2022/0552

Conversion of existing barn and stables to ancillary residential use and alterations and extensions to existing dwelling

Small Lanes Farm, Small Lane, Cawthorne, Barnsley, S75 4EF

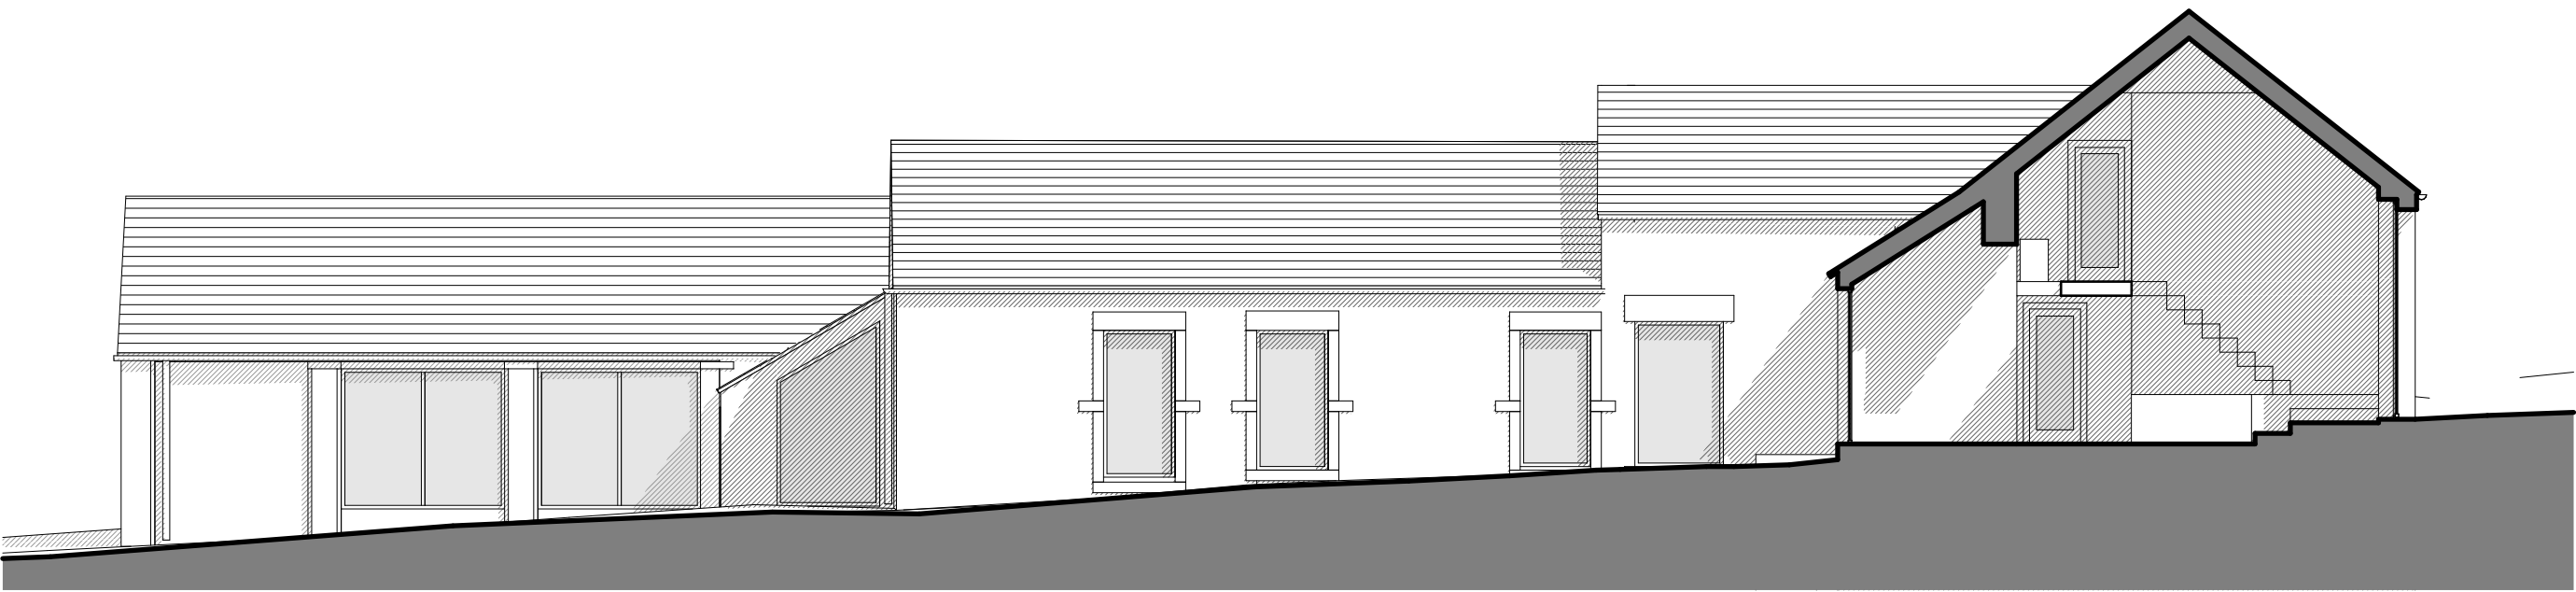
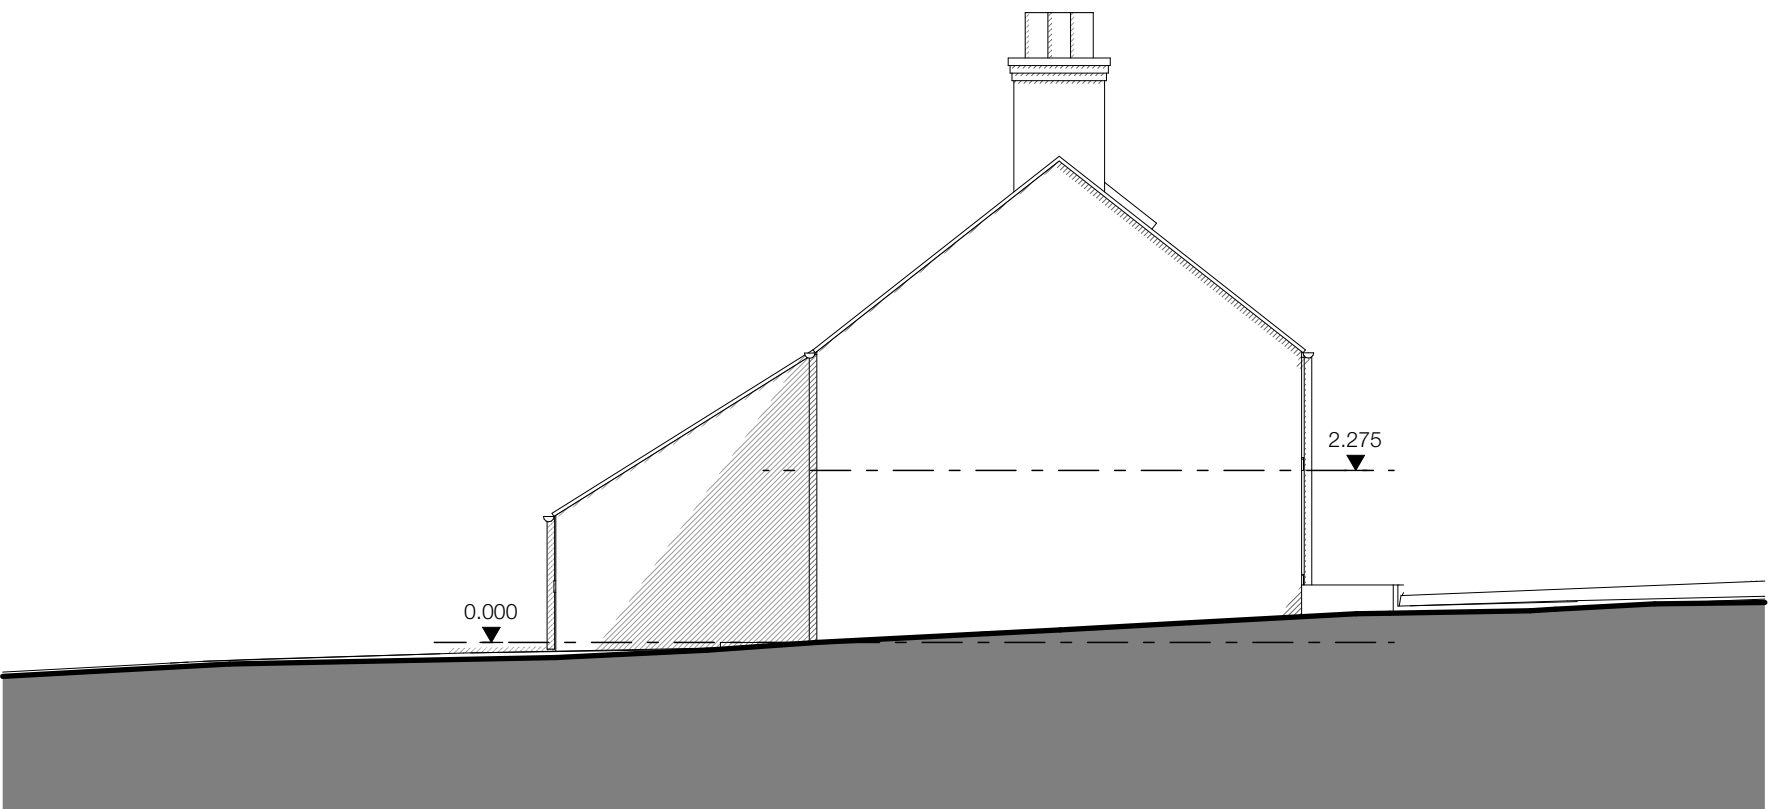
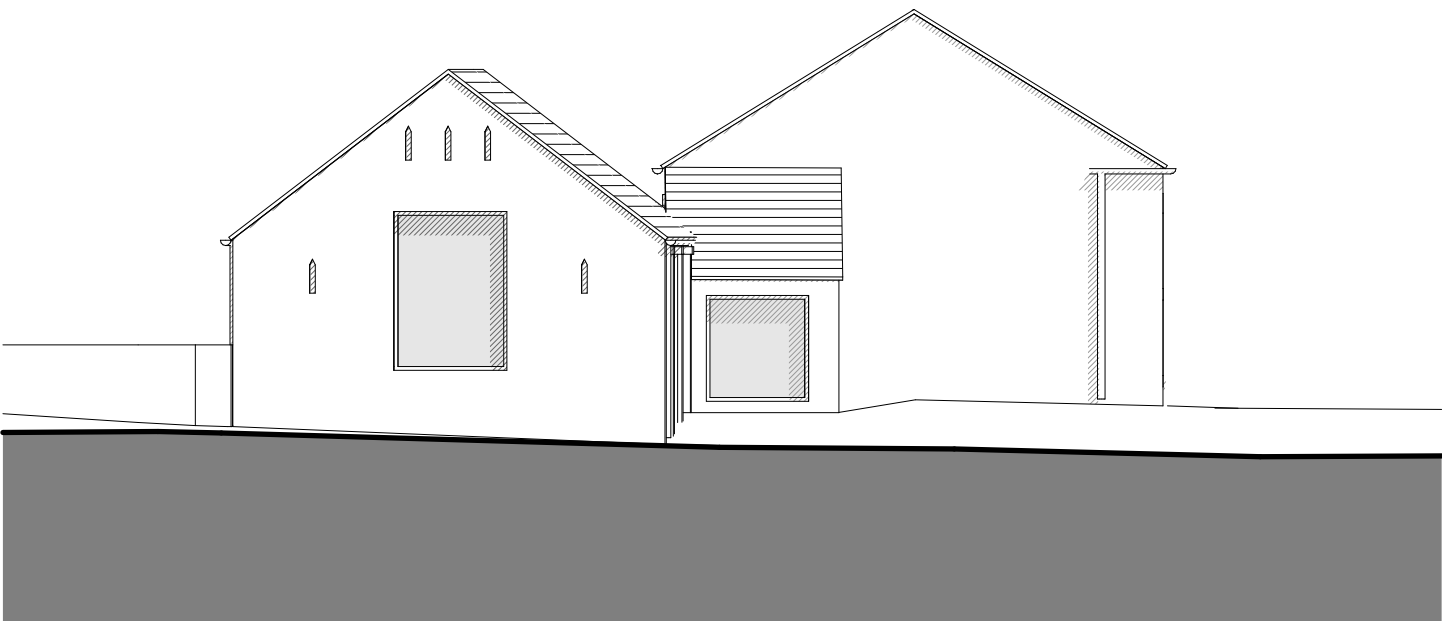
The external alterations include the insertion of new windows and doors to the existing dwelling and to the converted outbuildings. A small dormer style window and 3 additional windows at ground/first floor are proposed to the existing dwelling on the south west elevation and the insertion of full height glazed openings to the outbuilding. To the south east elevation of the stable, one window is proposed to the gable end. To the north west elevation, the existing windows are retained and a new glazed opening is formed to the existing barns door. To the south east elevation, there are very little changes with the exception of the new porch area. To the north east elevation new glazed openings are formed within the existing barn/stable doors and full height glazed openings are proposed to the stable block to replace the existing openings.

The proposed alterations have been sympathetically designed to meet the guidelines of the SPD Barn Conversions. Whilst the buildings are not listed, they do form part of the original Small Lane Farm and their retention is supported. New openings are limited to what is necessary and the proposed alterations and extensions will be constructed of high quality materials. The extensions to the dwelling are designed so that they are subservient to the main dwelling and are small in scale relative to the size of the original buildings. They are considered acceptable and should not significantly harm the openness of the Green Belt in compliance with policy GB2 and GB3.

Title. **SITE PLAN**

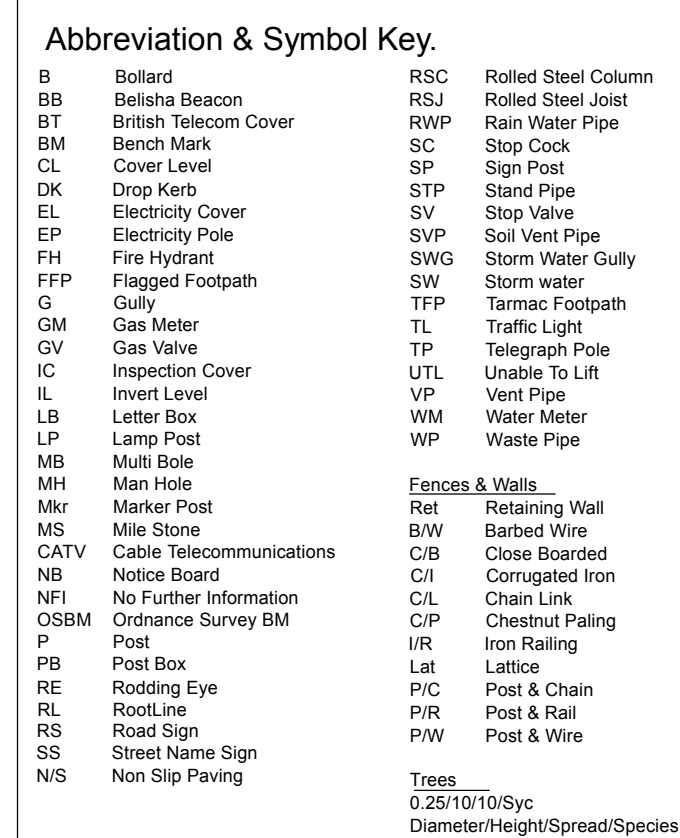
plans show Small Lane as a public footpath. However, this is incorrect. Small Lane is a public bridleway with a recorded width of 2.0 metres and is also recorded on the List of Streets as a highway maintainable at public expense.

The plans show that the PROW will be unaffected by the proposals, with no change to the footprint of the building. Safe public access should remain in place on the full width of the bridleway throughout development.
